Application: SSI 7485

I write regarding the proposed modification to M4-M5 Link, Mod 2 The Crescent overpass and changes to pedestrian infrastructure in North Annandale, Rozelle and Rozelle Bay Foreshore area. *I object to the overpass & the relocation of the GreenLink, and*

Figure 4-2 Pedestrian and cyclist bridge infrastructure options

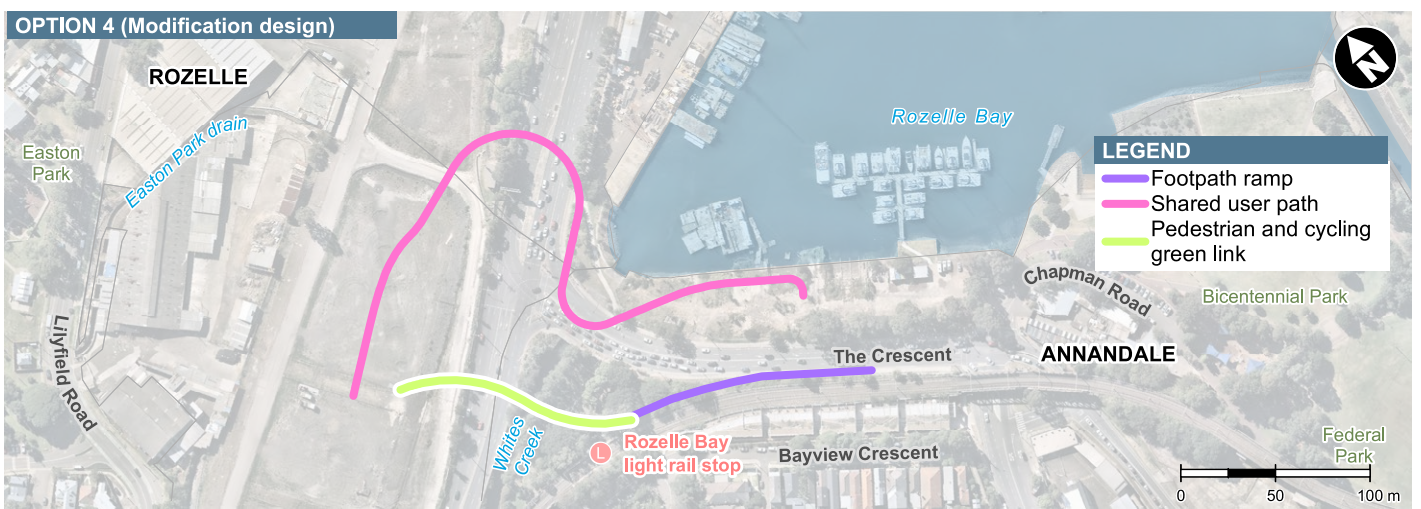
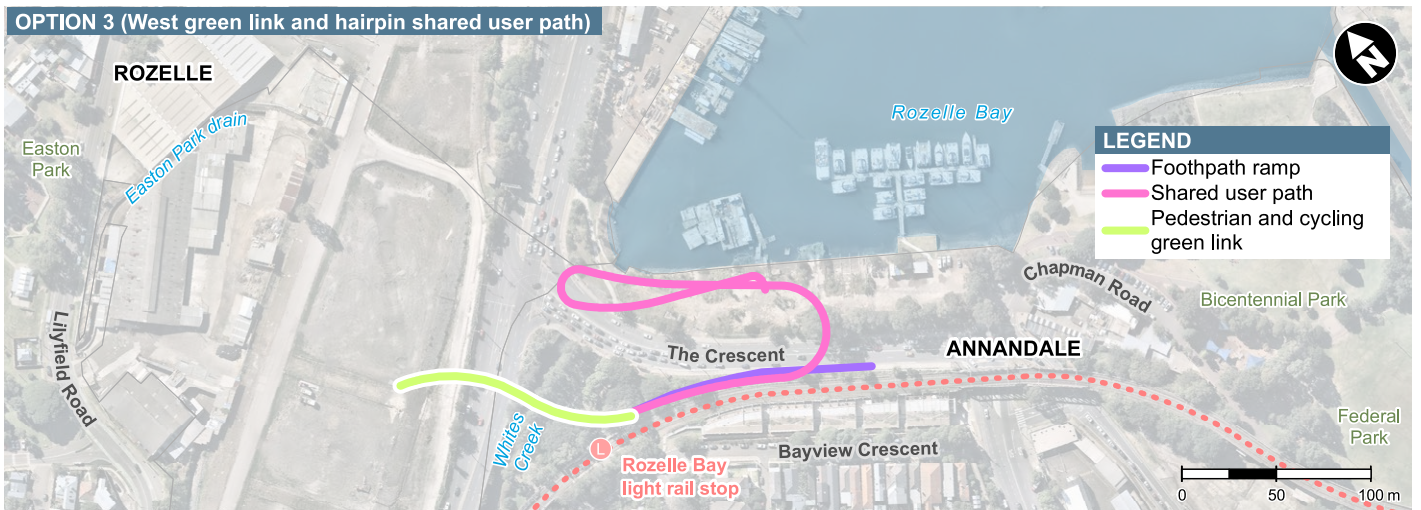
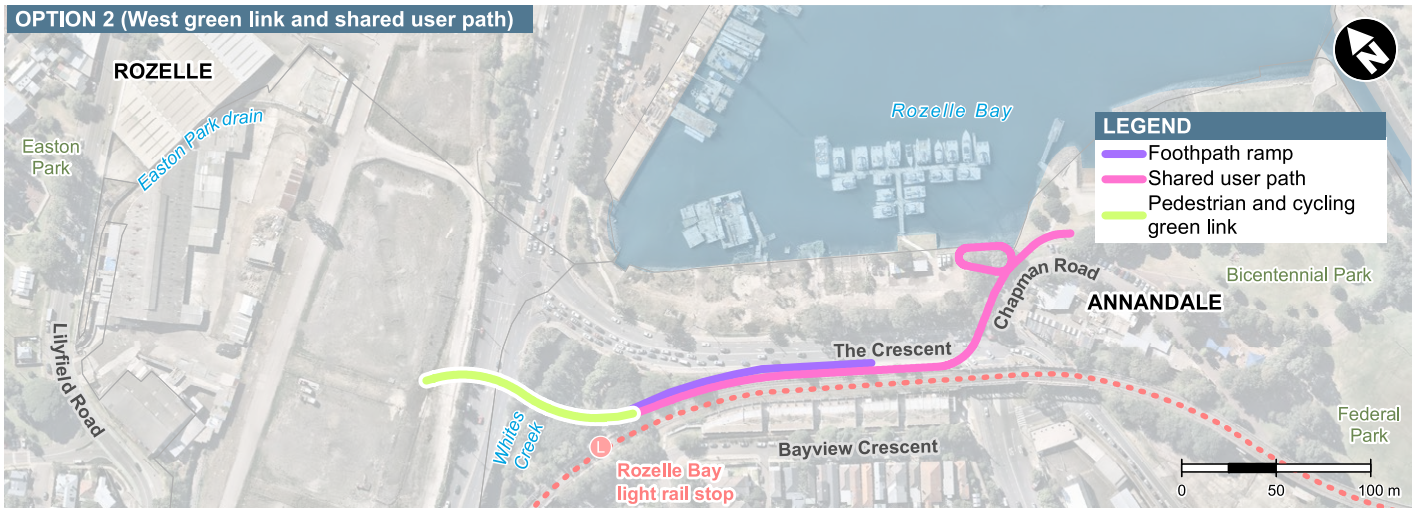
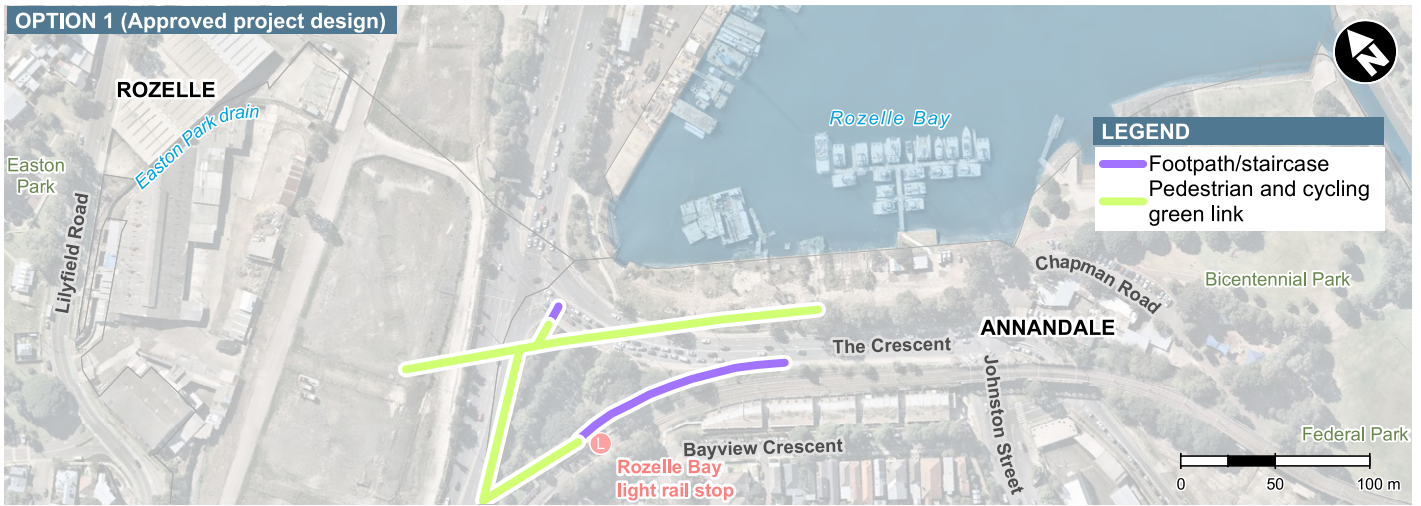
I request RMS work with the community to explore alternate design options to the proposed new car overpass design and the changed pedestrian and cyclist links. I am seeking the reinstatement of the safe, direct access from the approved EIS GreenLink to create a continuous green open space connection from the Rozelle Rail yards and Annandale to the foreshore. The GreenLink was more than just a walk way - it put people central to the design, maximising safety, and providing much needed accessible open space for the community now and into the future Bays Precinct design.

- The significantly reduced safety and increased risk for pedestrians and cyclists with removed access over The Crescent to Bicentennial Park and the increased traffic along Johnson Street.
- Being required to cross five sets of pedestrian lights at The Crescent as my option to reach the foreshore from Annandale or from Rozelle Bay light rail stop.
- Removal of direct active links to the foreshore, cutting the community off from the area and the proposed revitalisation of the entire Bays Precinct, including linking the Light Rail and Bus stops to a Ferry wharf and Metro station.
- Urban and landscape design that is being built before a finalised Masterplan for the area.
- Traffic changes that limit movements around the suburb and create further congestion in the local streets of Annandale, Forest Lodge, Glebe, Lilyfield and Rozelle with no planning to deal with these.

- Reinstate the GreenLink connecting communities and green open space from Rozelle to Bicentennial Park
- Relocate and design pedestrian and cyclist connections that are continuous, safe and direct.
- Design the modification infrastructure and active links in response to the character of the suburbs, the location of the foreshore and its potential future development.
- Provide pedestrian and cyclist paths that maximise people safety and do not force them onto busier streets, unsafe concrete plazas and caged walkways.
- Integrate active and direct connections to all active transport – including the future Metro West and Foreshore Ferry Wharf
